**From:** [REDACTED]  
**Sent:** 20 March 2025 10:02  
**To:** Planning  
**Subject:** Planning Application Comments - 3/2025/0100 FS-Case-697904505

**Planning Application Reference No.:** 3/2025/0100

**Address of Development:** Hotel on eagle car park

proposed site plan
scale - 1:250@ A1 / 1:500 @ A3

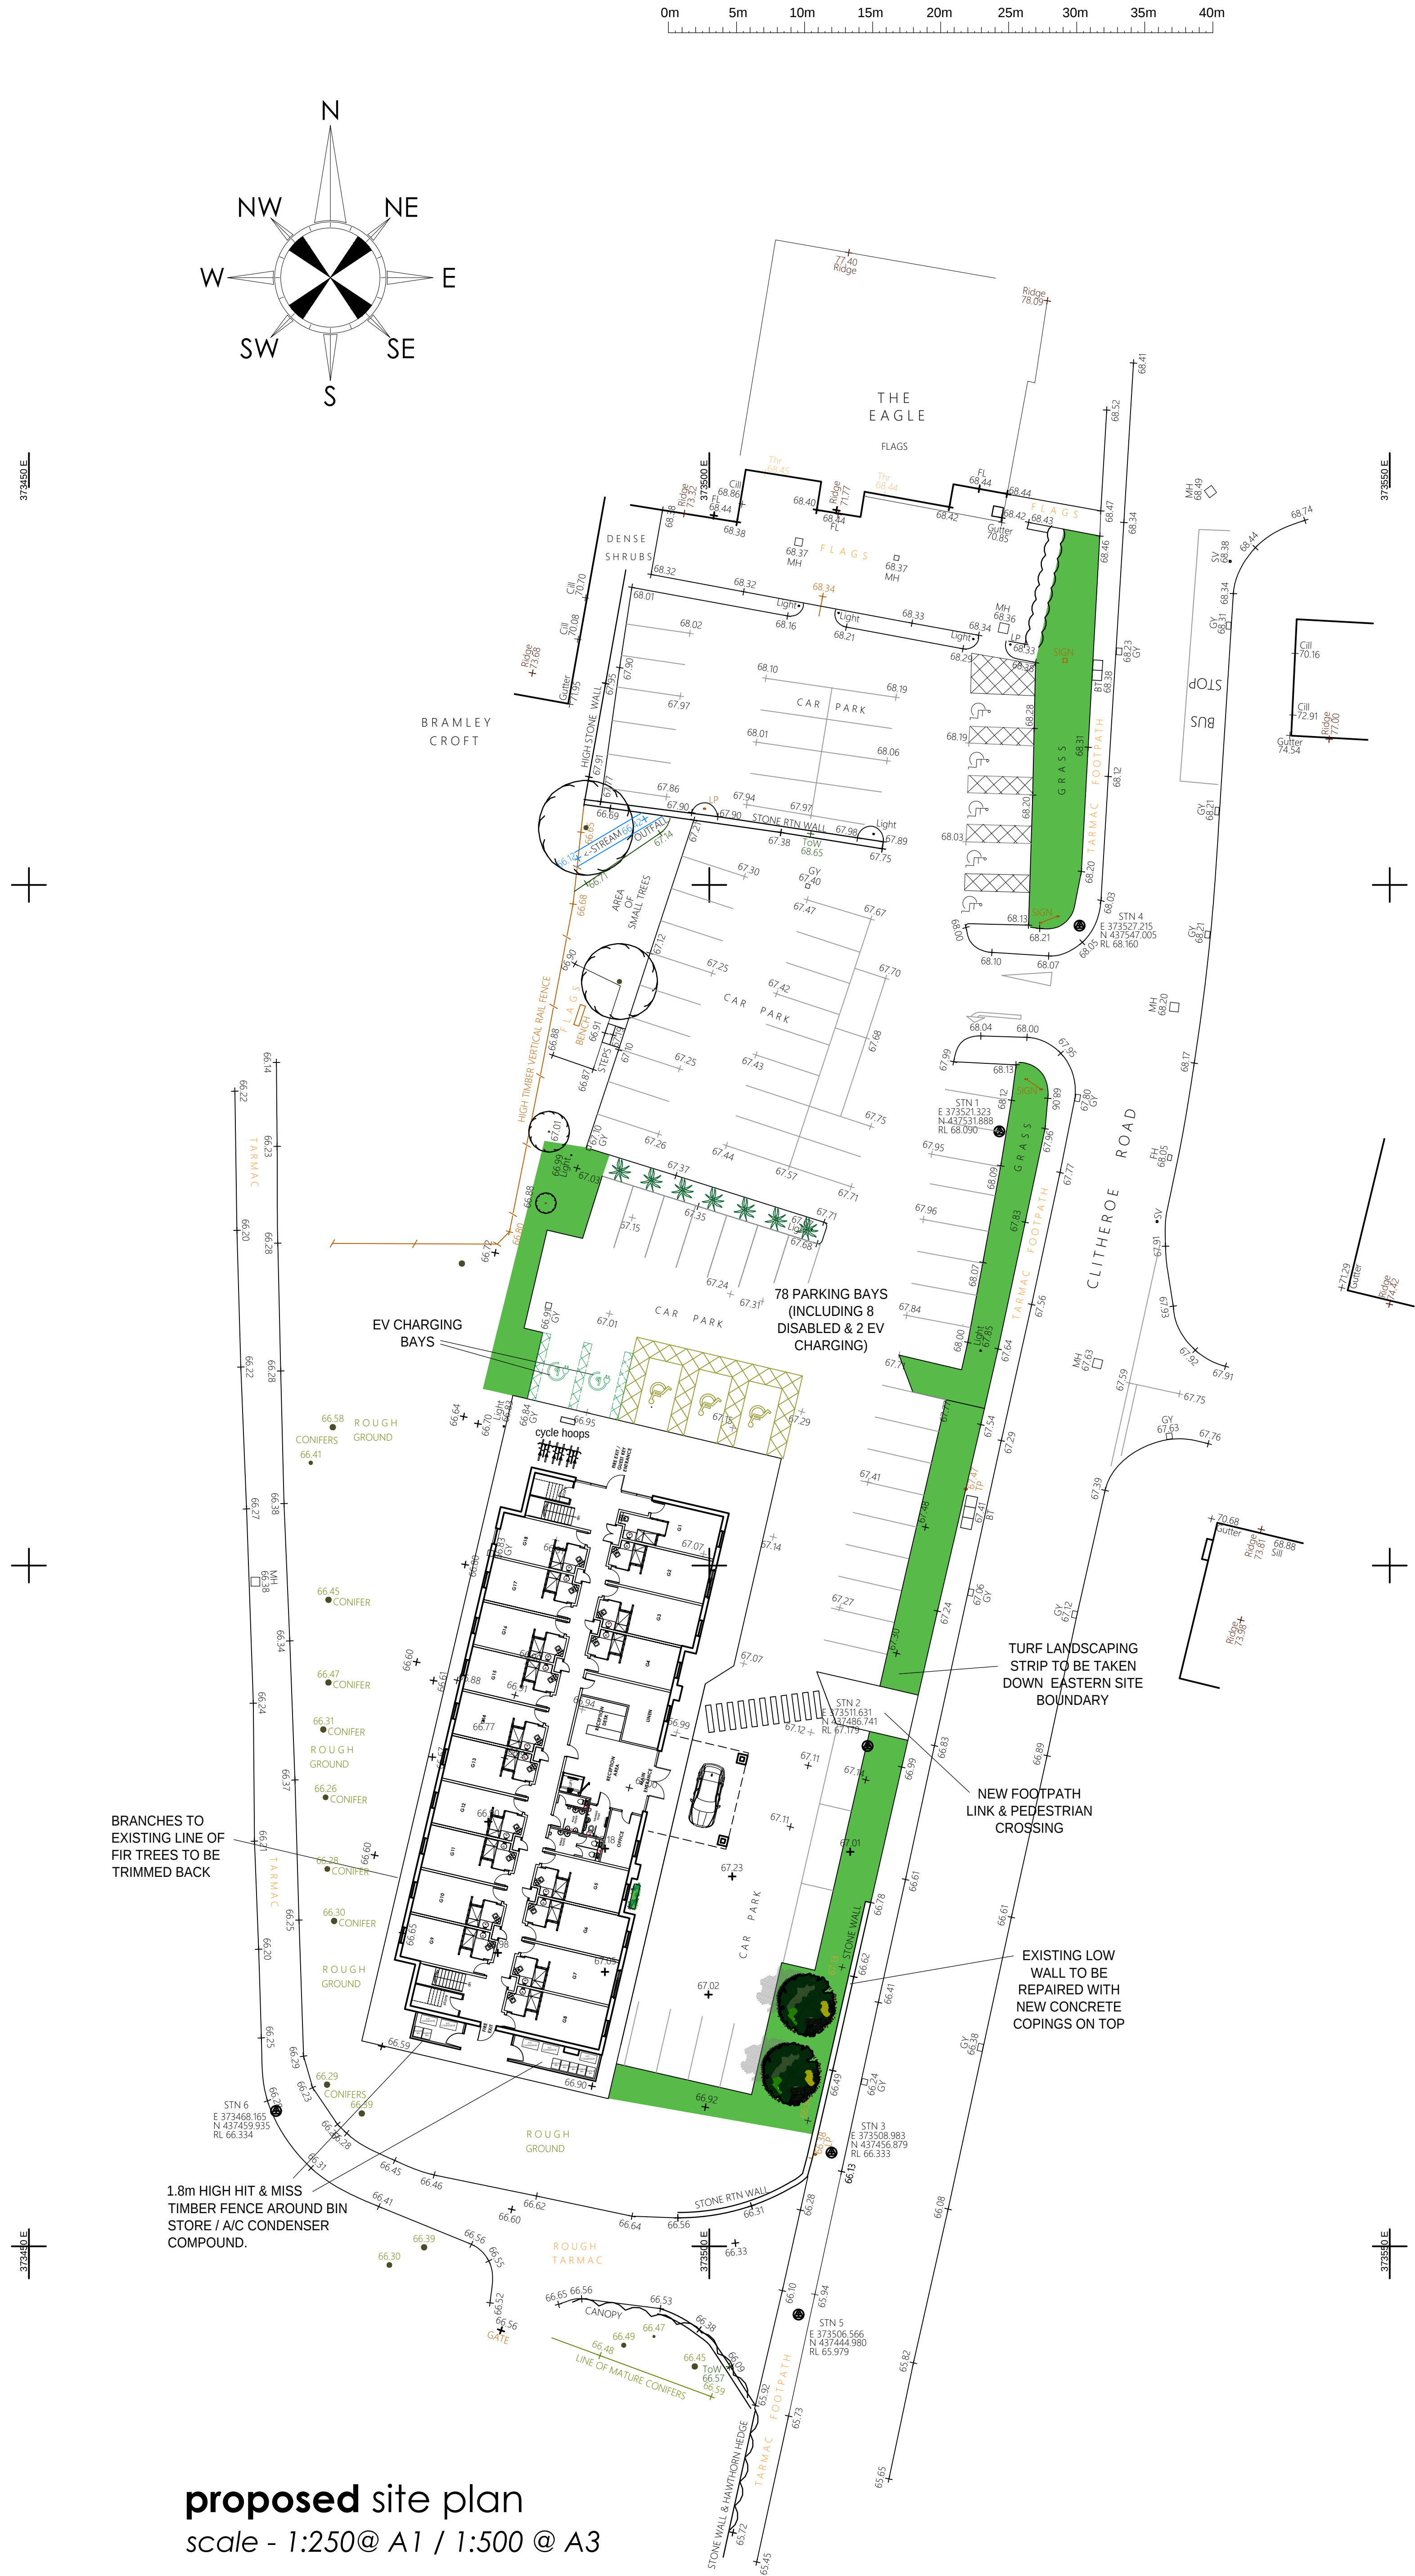
1. There appears to be a protected footpath from the hotel to the restaurant, considering this will have high footfall and car traffic I feel this is important to protect the children
2. There does not appear a safe space for children to play. This hotel will increase the number of families on site, with young children. Currently they play on the car park which is not safe. But this will be exacerbated by more people and reduced space taken up by the hotel. Ideally I would like to see some protected space and facilitates for family to play safely
